CITY OF PORTLAND, MAINE

Project Name: Residential townhouse - 6 unit condominium
Project ID: 2013-187
Project Address: 133 York Street
CBL: 44-1-29 &31
Applicant: 133 York, LLC, Applicant
Planner: Jean Fraser

On January 28th, 2014 the Portland Planning Board considered and approved a Level III Final Site Plan and Subdivision proposal for the construction of a 6 unit residential building at 133 York Street.

10 TREE FILTER DETAILS

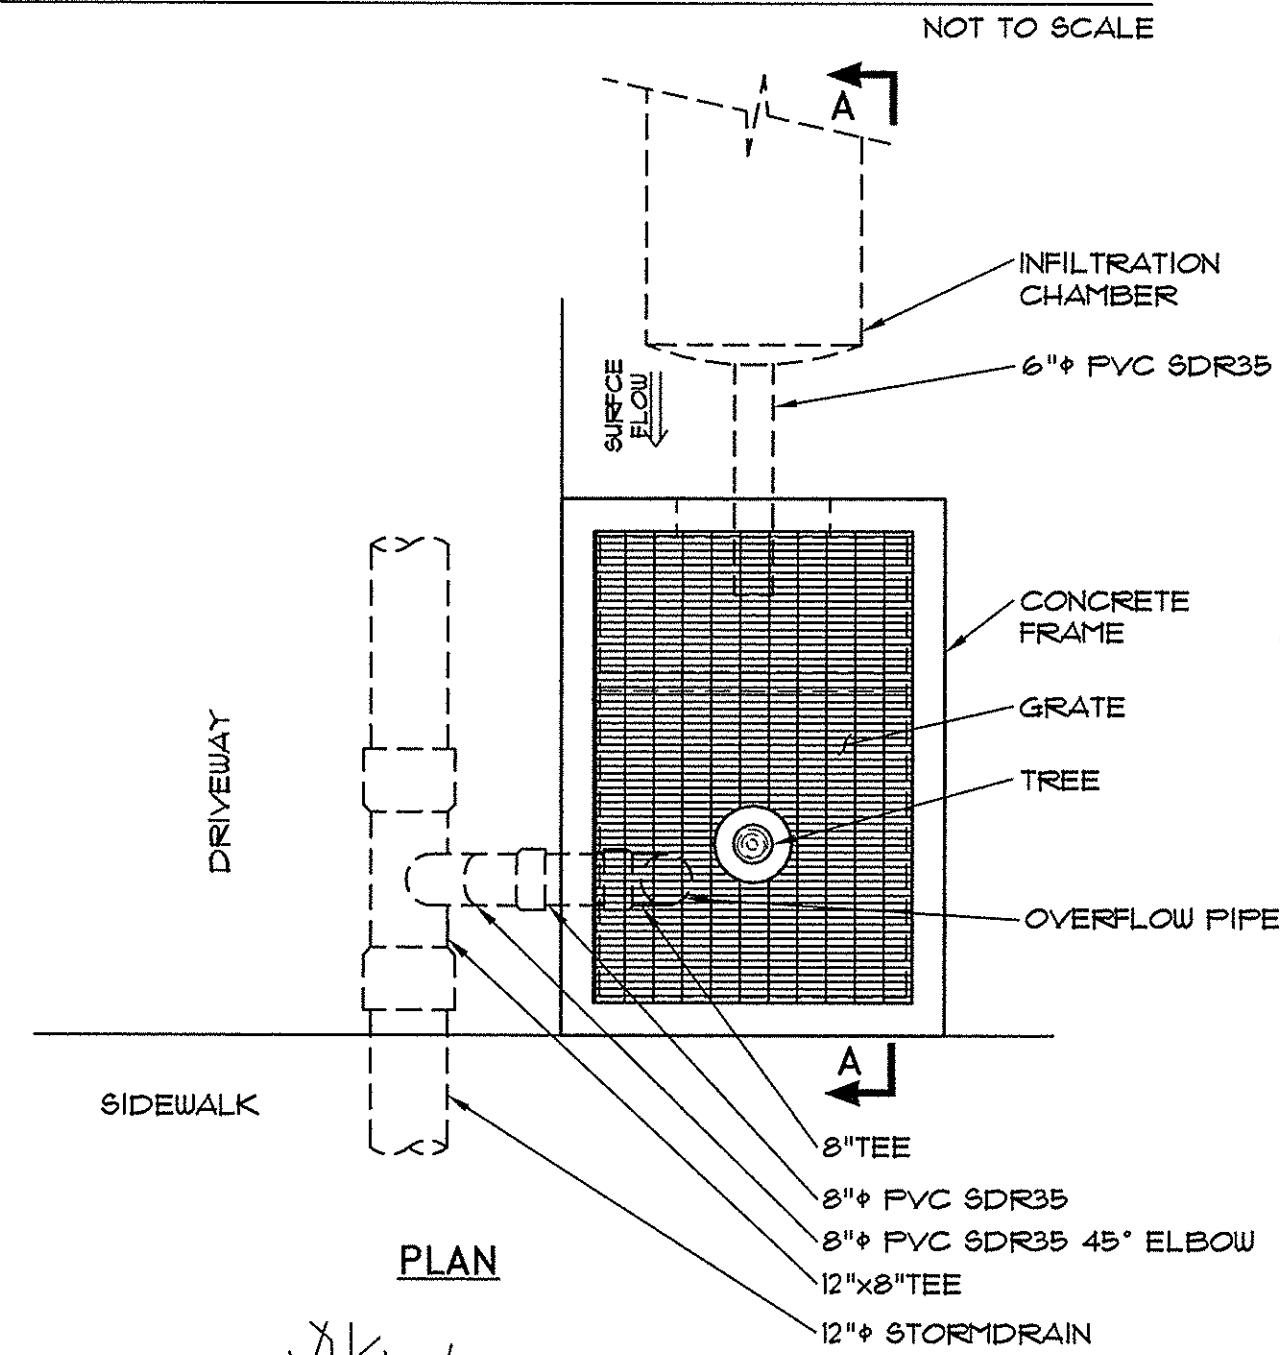
location of tree filter and ref stormwater system maintenance (confirming that this is not city and referring to agreement etc)

8 TREE PLANTING DETAIL

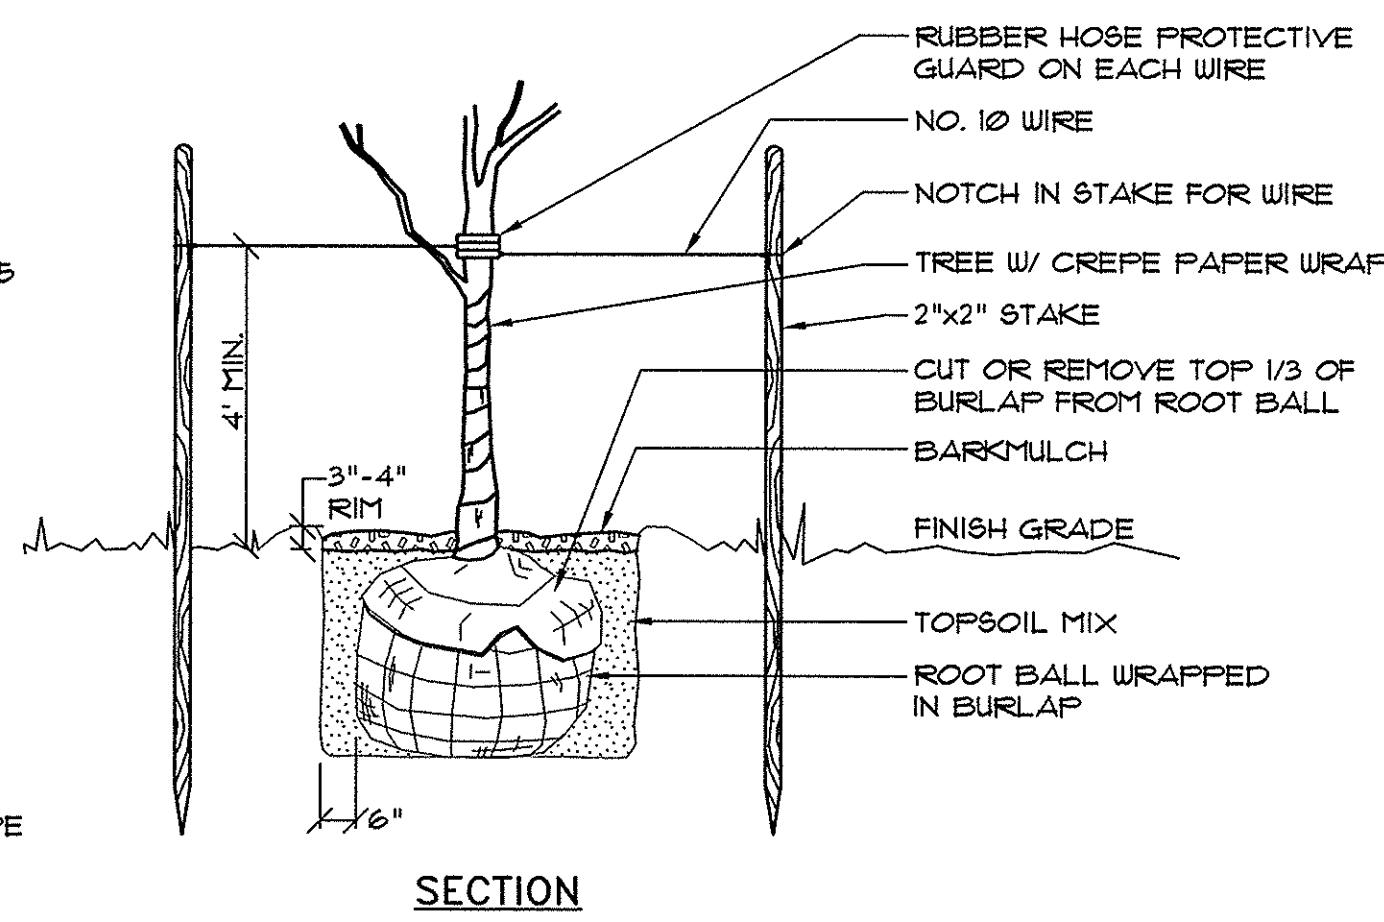
Tree Types - ALL trees should be from the City of Portland recommended list, (Little-leaf Linden is no longer on our recommended list). Suggestions might include: 'Karpick' or 'Red Point' Red Maple, 'Armstrong' Red Maple, the first two are a little less columnar the Armstrong, European Hornbeam, upright Pin Oak also would work, this is the same for the lawn area trees above if needed.

b) landscape plant material: plant sizes - Condition) shrub stock noted as "D" Clethra, "F" Deutzia, "J" Northern Bayberry, "K" Climbing Hydrangea, "L" Stephanandra shall all be #3 pot size minimum and tree sizes should be the following: "B" Flowering Crabapple 1.75-2" caliper, "C" Armstrong Red Maple 2" caliper. Items mentioned as "Existing", "G" Relocated Japanese Maple (#5 pot size), "H" Relocated Lilac (3-4'H) should also have these sizes as replacements if the relocation is not successful. (Too often good intent to save plants through construction are less then successful).
